Recommendation Report for Planning Permission for Works or Extension to a Dwelling

REF NO: M/70/17/HH

LOCATION: 10 Norfolk Way
Elmer

PROPOSAL: Two storey side extension & loft conversion.

ELEVATION FACING WEST

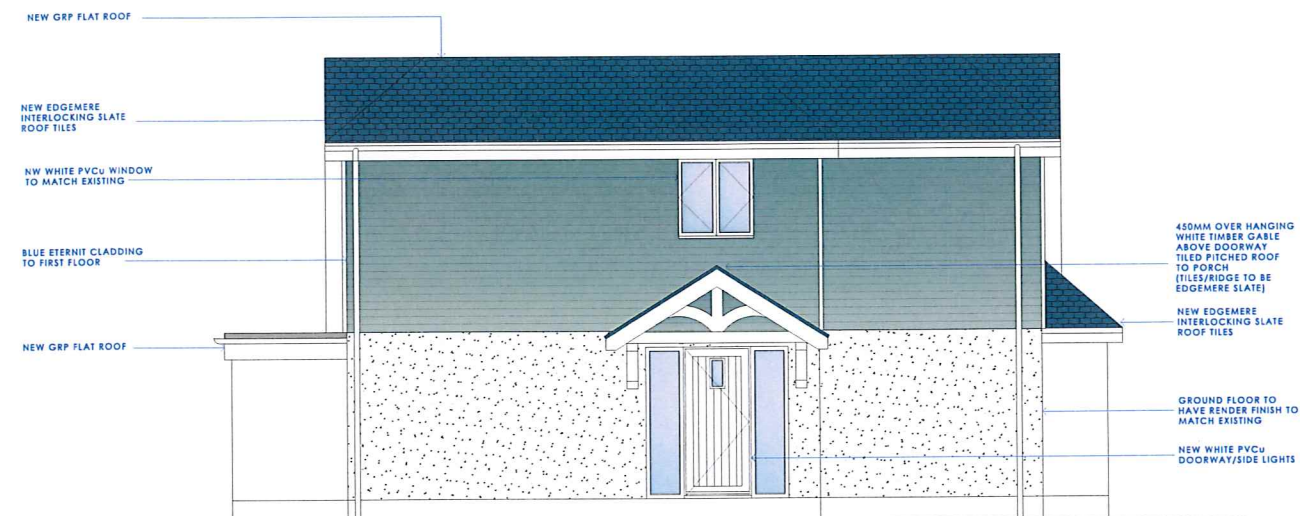
The first floor window of the West of the property is a cause of potential overlooking and therefore will be conditioned to be obscure glazed and fixed shut below 1.7m. The proposal include three windows on the Southern elevation of the property, however the separation distance to the nearest property is over 20 metres which is deemed to be sufficient to prevent any unacceptable loss of privacy.

The floor area of the proposal brings the current Western projection to meet inline with the main bulk of the house. This means that the proposal fails the 45 degree test in relation to the window on the South East of the neighbour to the West of the site. The failure is within 2 degrees of the test, at approximately 43 degrees. Given the slight breach, the impact is deemed to be acceptable, and as the property benefits from a Southern aspect there will be an acceptable level of lighting.

- 4 The window at first floor level in the Western elevation of the building (as seen on plan - Proposed Plan - PA-247-06) shall at all times be and remain obscurely glazed up to 1.7m with obscure glass and be fixed shut.
